References to pages 1 - 10 from document [230328-Final-Exhibition-Boards-compressed](#)

*The majority of these comments specifically address the eight Town Houses on the southern perimeter of the site, parallel with Dashwood Road. They are referred to as TH.*

Section through Townhouses showing comparable height with Dashwood Road properties

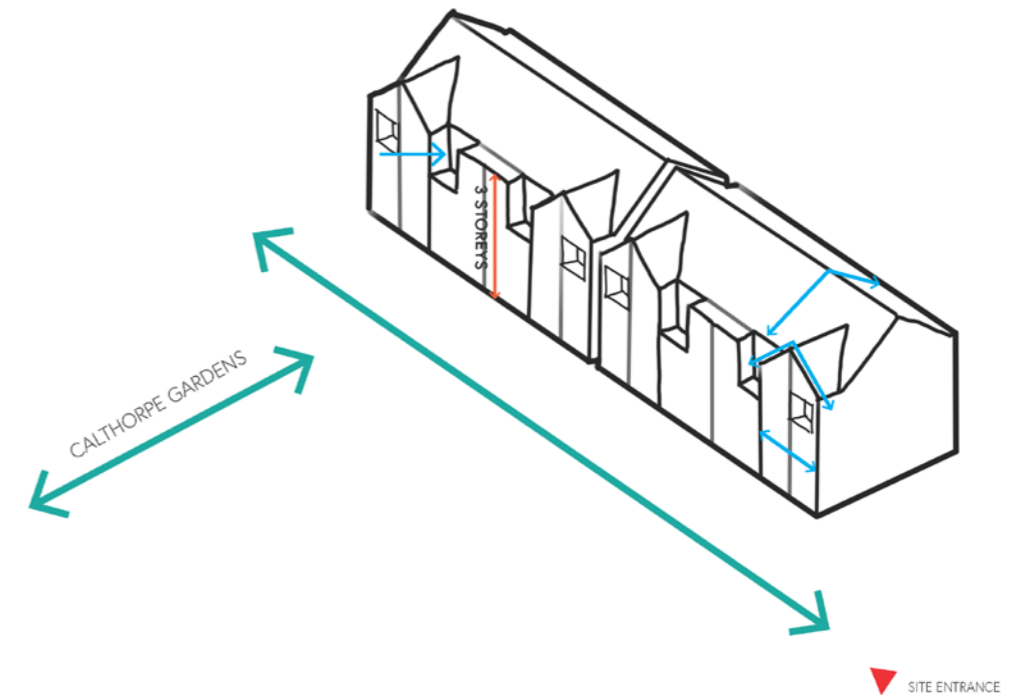
Page 7: Again, regarding the TH, what does '...building heights respecting the surrounding townscape' mean in practice? Will the TH not exceed the height of the existing Farmfoods and TK Maxx buildings?
